Bramford – Twinstead:

Deadline 10

Braintree District Council (20041141) &

PINS REFERENCE: EN020002

TITLE: Figure 1
 Proposed Archaeological Mitigation

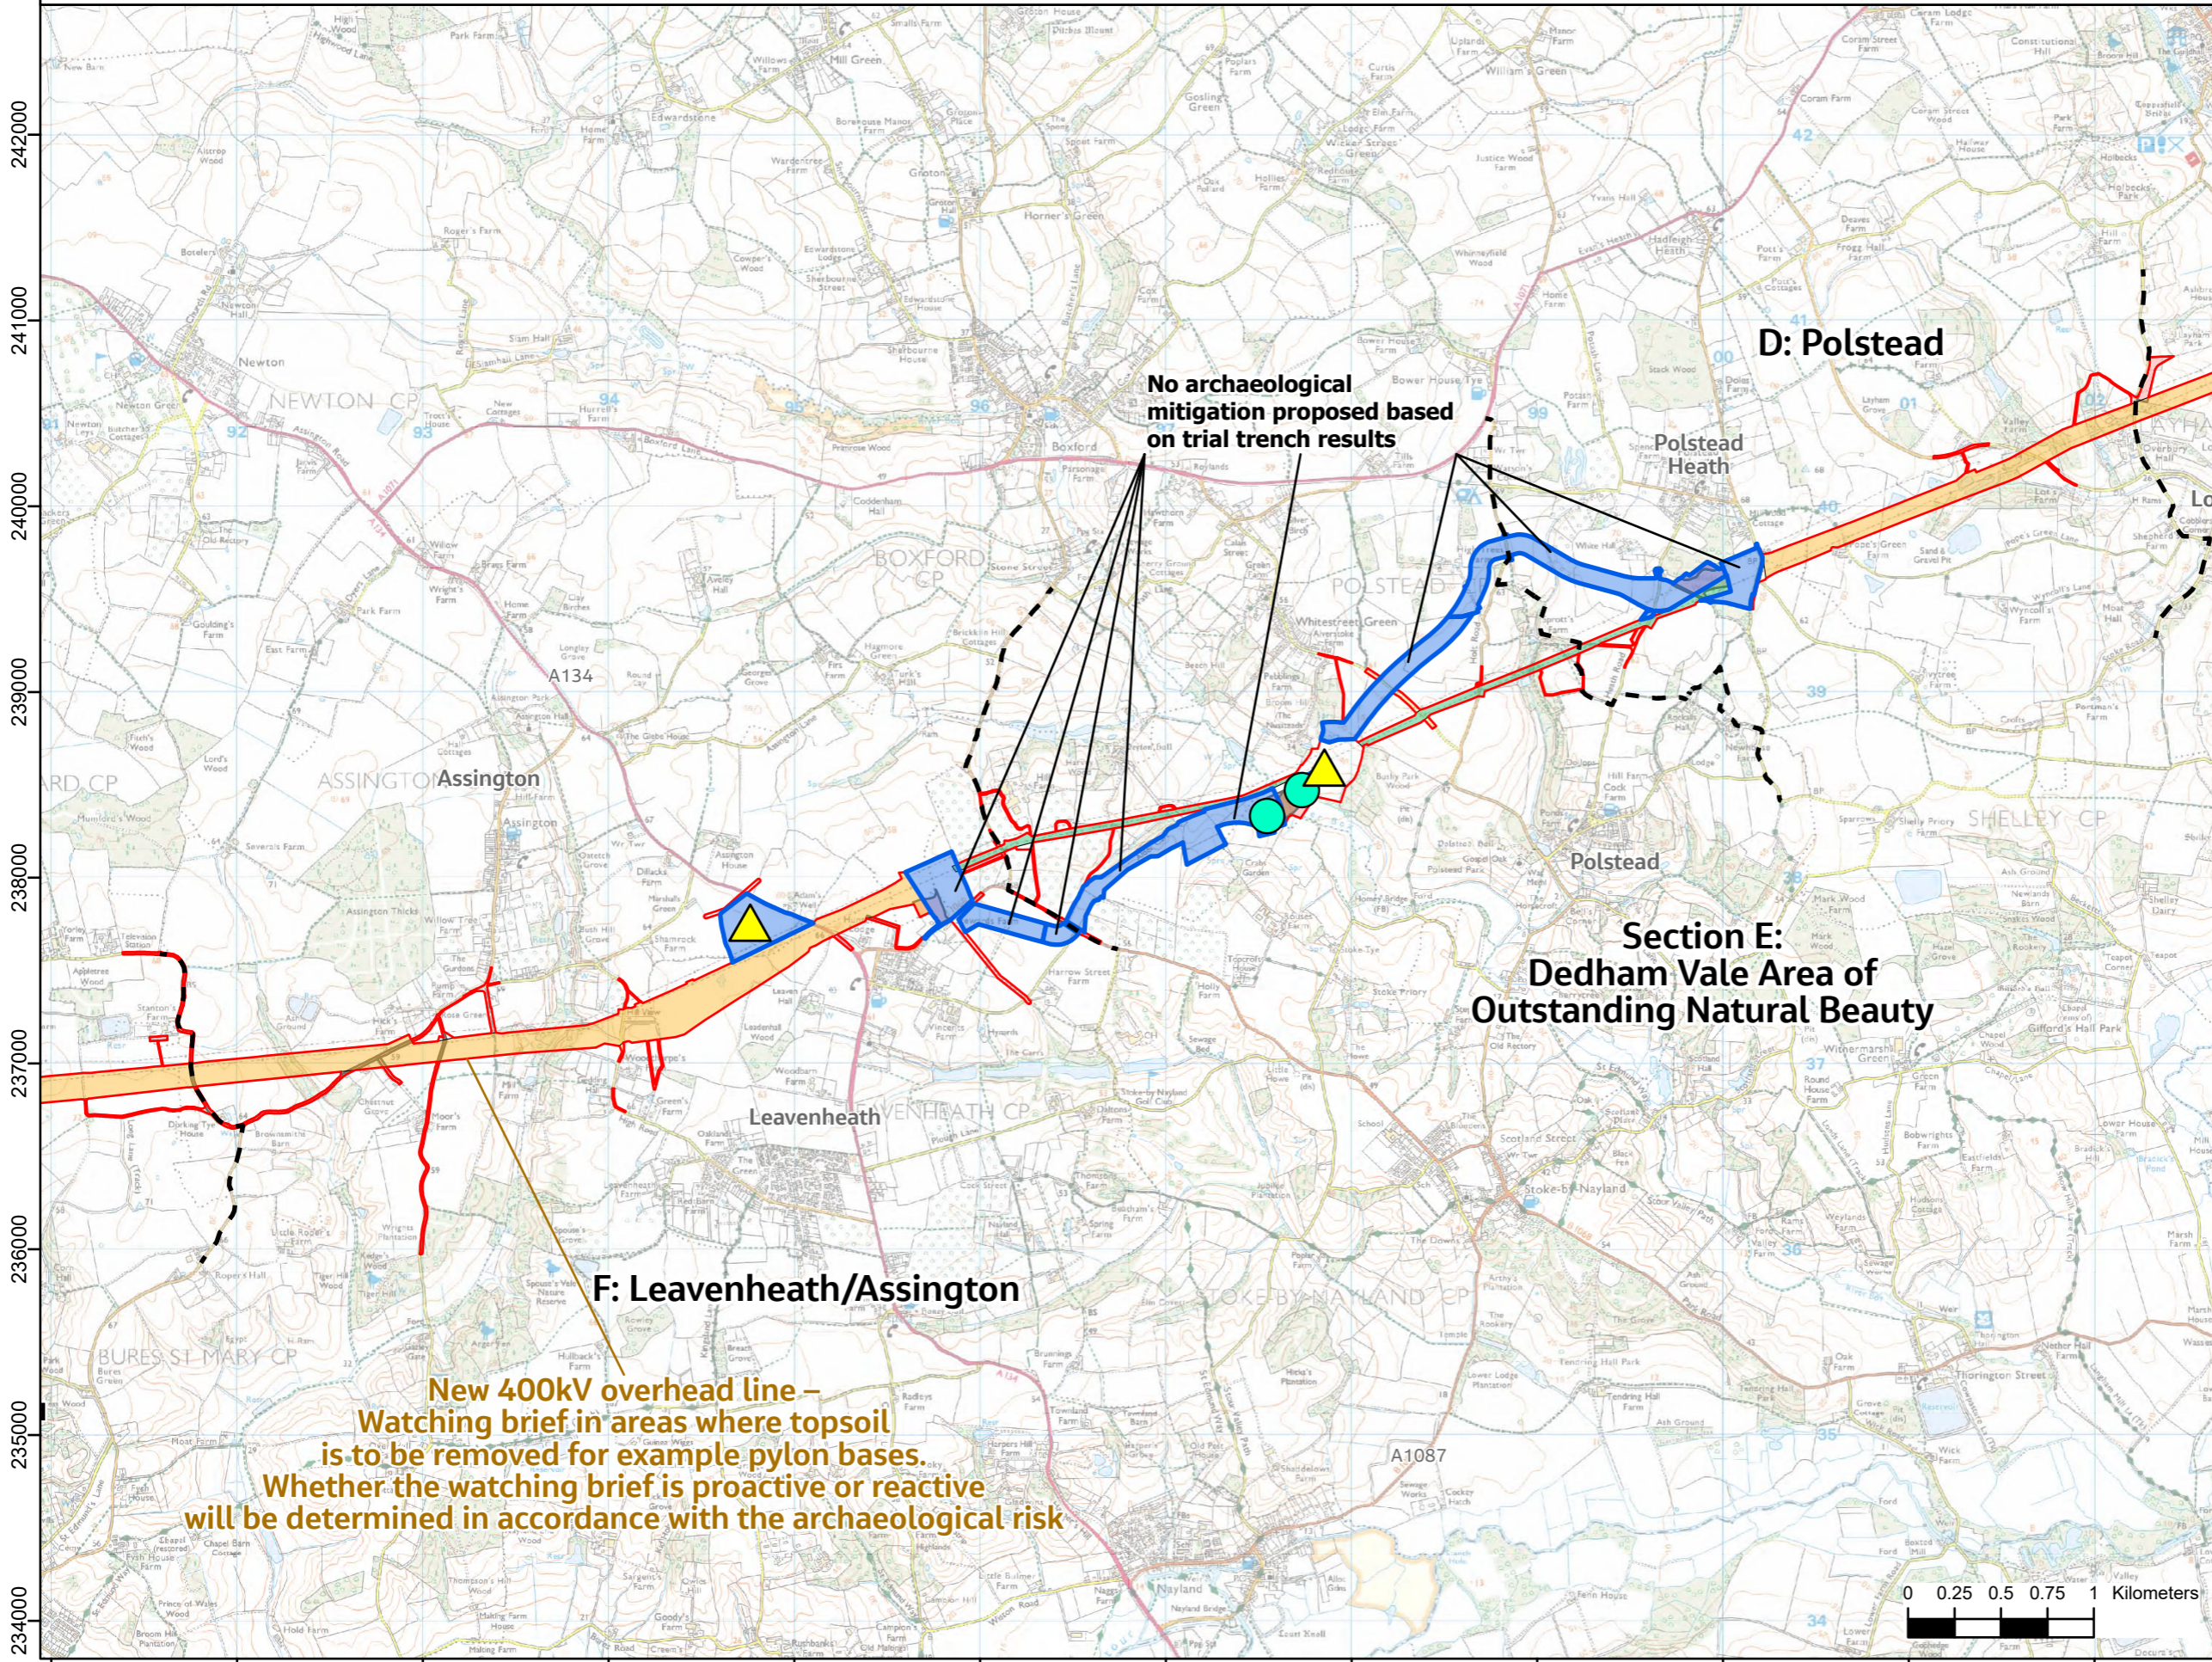
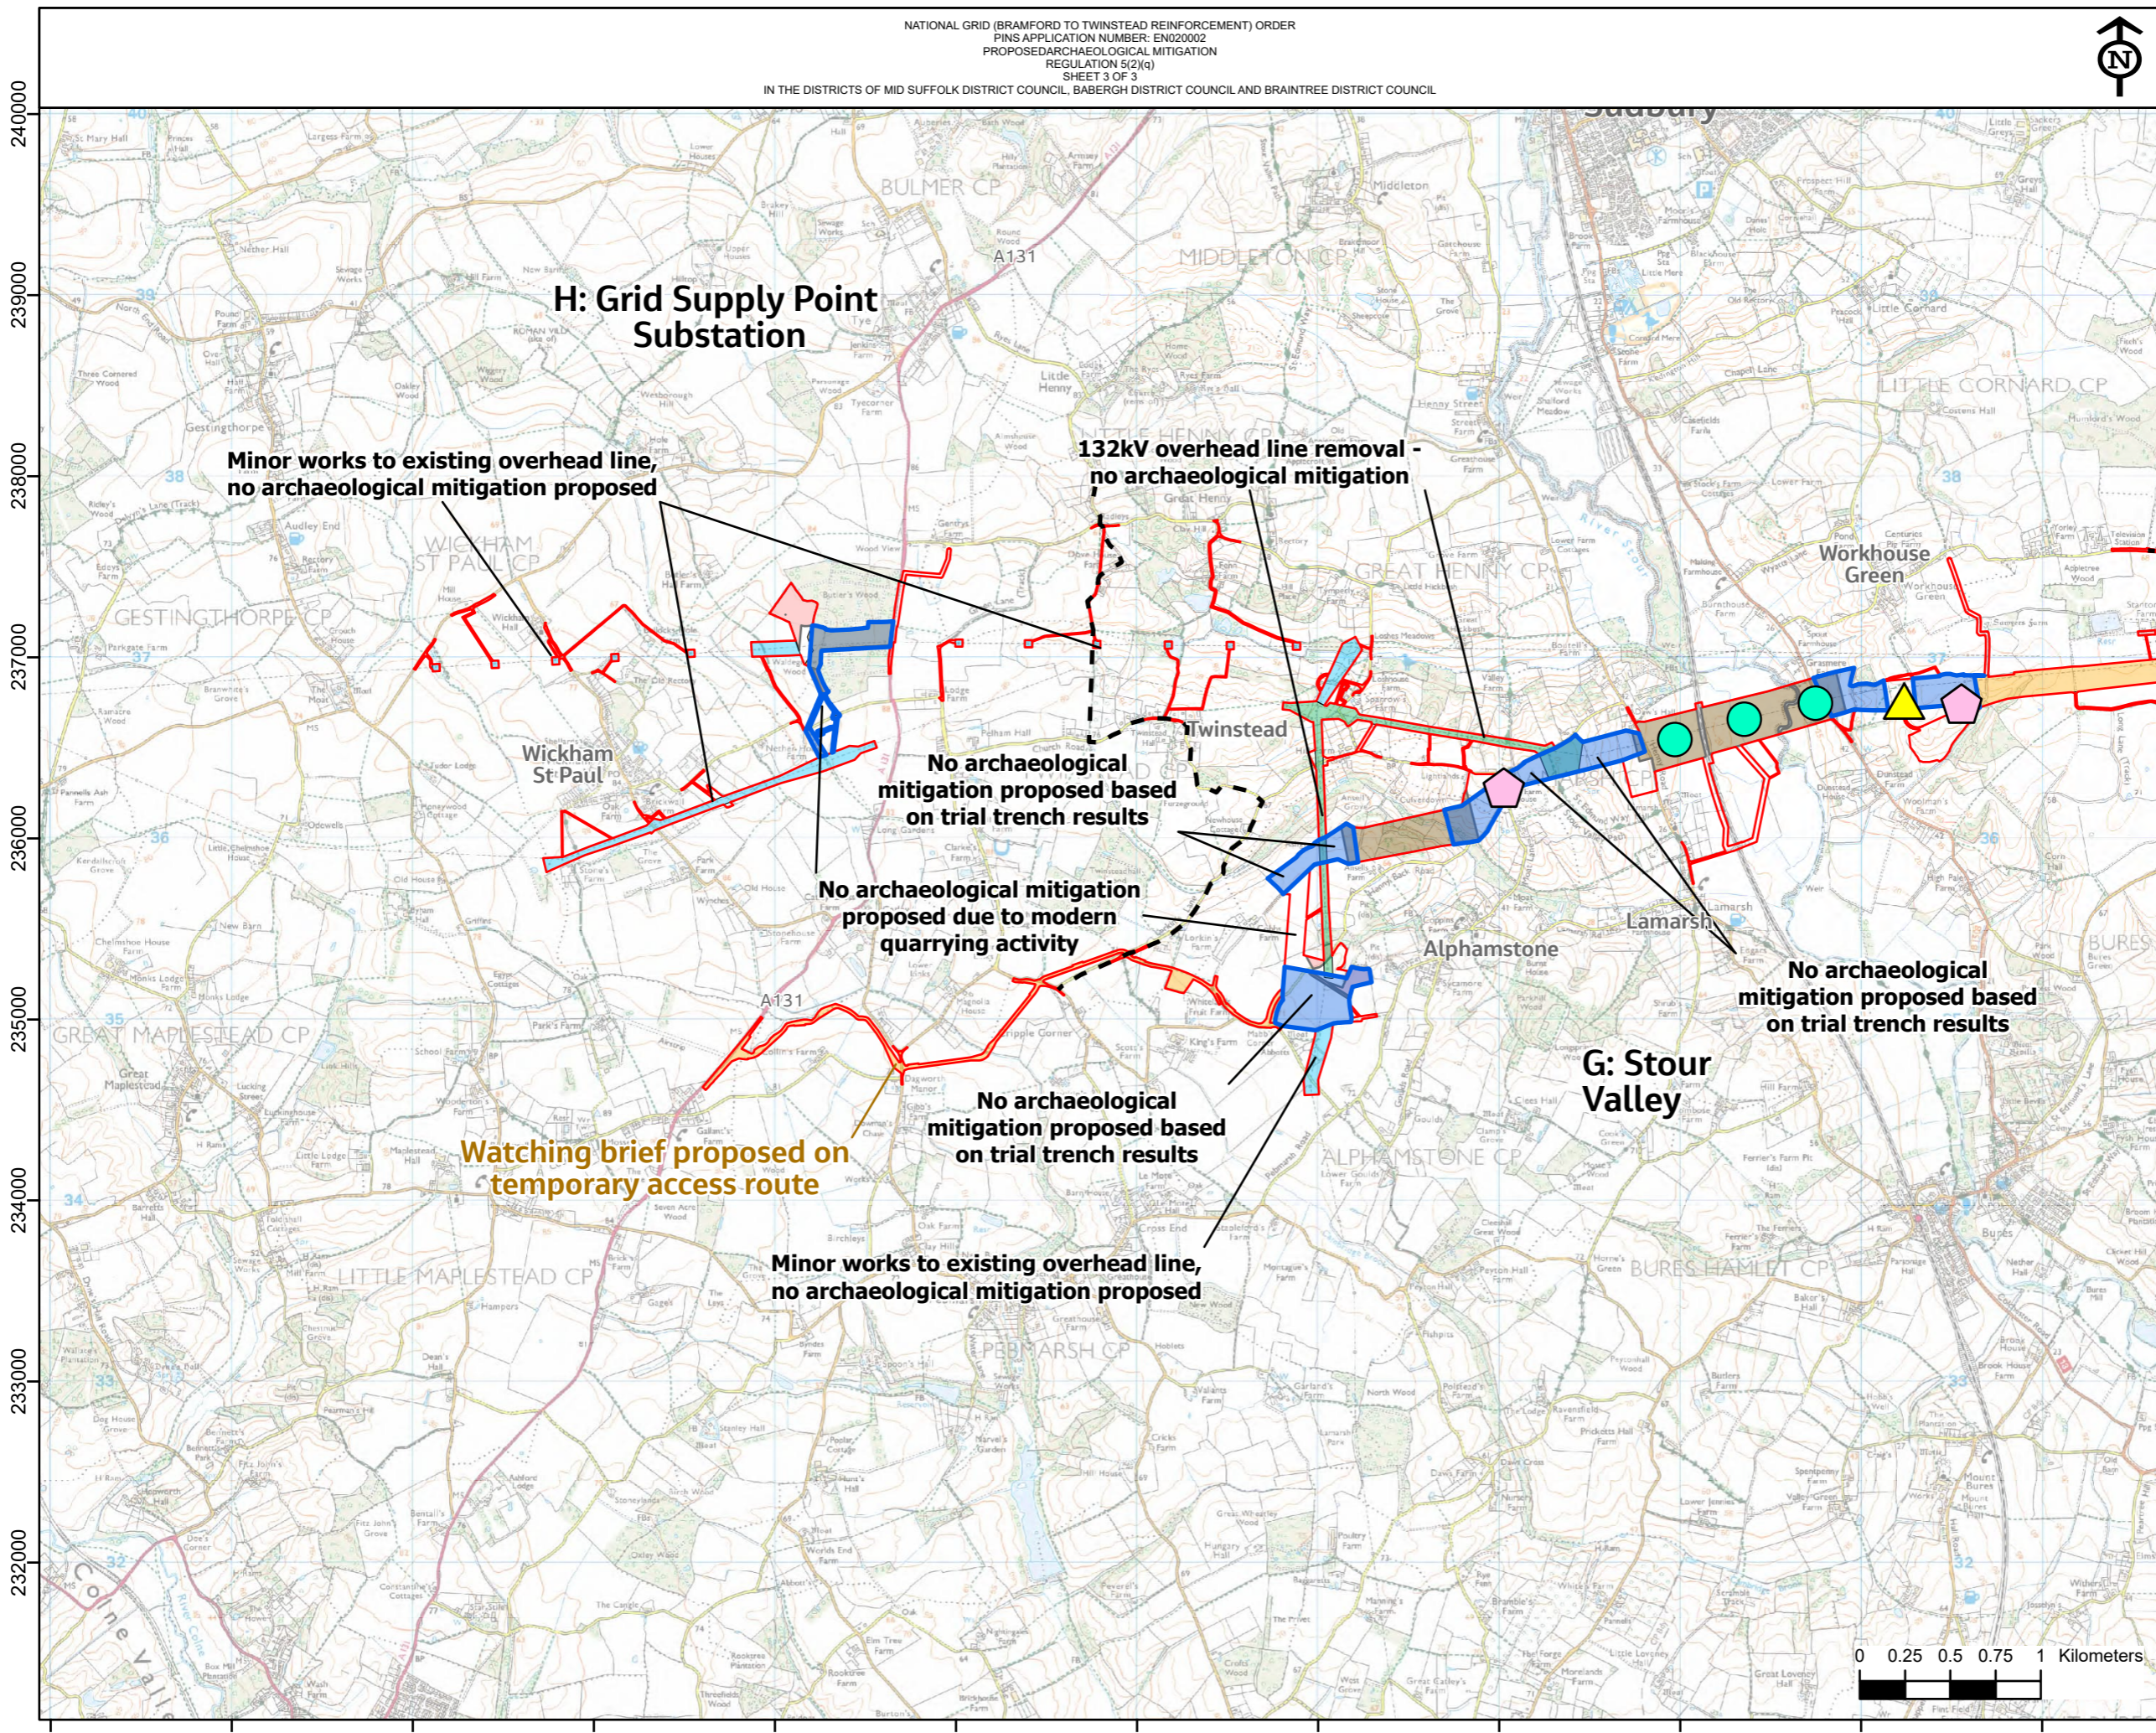
- 4.3.5 The Applicant has failed to provide sufficient information to identify areas that can be removed from the requirement for further archaeological work or mitigation at this time.

- 4.3.6 Removing areas from further investigation at this stage without adequate supporting evidence is contrary to what is stated in Document 6.2.8 Environmental Statement Ch 8 Historic Environment Section 8.8.2 which states that “ a level of archaeological mitigation would be applied to all archaeological remains where removal or damage is unavoidable, whether significant or not, as per good practice”.

- 4.3.7 In addition, mitigation is proposed in areas which have not been subject to any archaeological evaluation such as access roads, temporary compounds, planting etc. Archaeological monitoring and recording would not be recommended on areas where the potential for archaeological remains is unknown. These areas should be the subject of an archaeological evaluation by trial trenching in the first instance. This would allow a suitable mitigation strategy to be proposed.
